From: Fiona Bennett [REDACTED]
Sent: 07 April 2017 13:59
To: 'Ian Gledhill'
Subject: RE: Pagham South P/140/16/OUT

As promised, please find attached the revised access drawing showing the two new pedestrian crossings over Pagham Road as set out in your email below, as well as tactile paving over the Village Hall access.

Figure 5.2 – Proposed northern site access junction

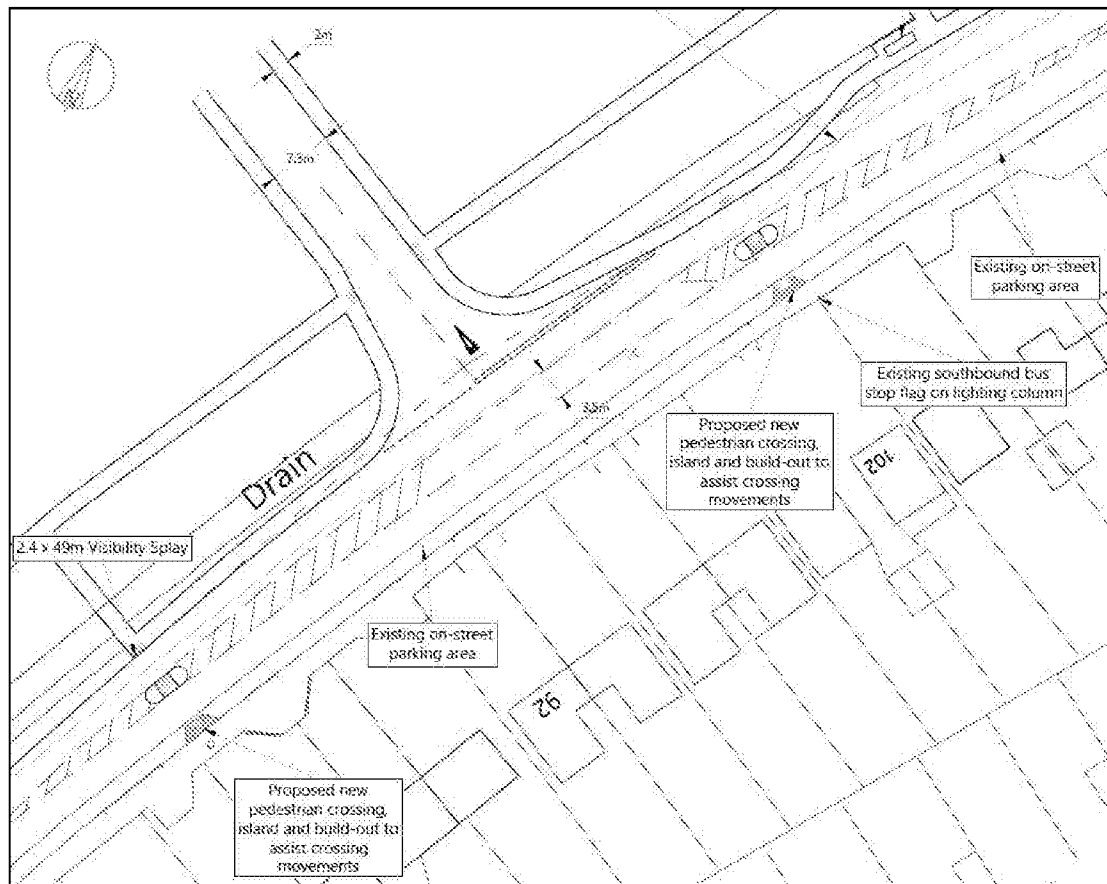
- iii. I can understand the reasoning why this was left as an island rather than made up to a refuge. However there is the potential for crossing demands in the vicinity of the northern vehicle access; I'd suggested that it would be better to try to accommodate these demands that will occur rather than leaving pedestrians to crossing without any provision. This may also be something worth clarifying with the Safety Auditor as their recommendation is to provide a crossing, and it's unclear if they've accounted for the presence of the bus stop when making their comment.

I'd suggest that a crossing point would be needed further north (as per point i) as there is no continuous footway on the western side of the carriageway.

I have issued in draft for your comment, and I also attach a photograph looking north at the mouth of the Village Hall access. You will see that there is currently no footway to the immediate north of the Village Hall and that there are trees in the verge; one of which will be impacted by the new footway and crossing point over Pagham Road to the north of the Village Hall access. Please can I have your thoughts on this? If we are providing a crossing both to the immediate north and south of our northern access junction (as shown on this drawing), do we also need to provide a crossing at the Village Hall?
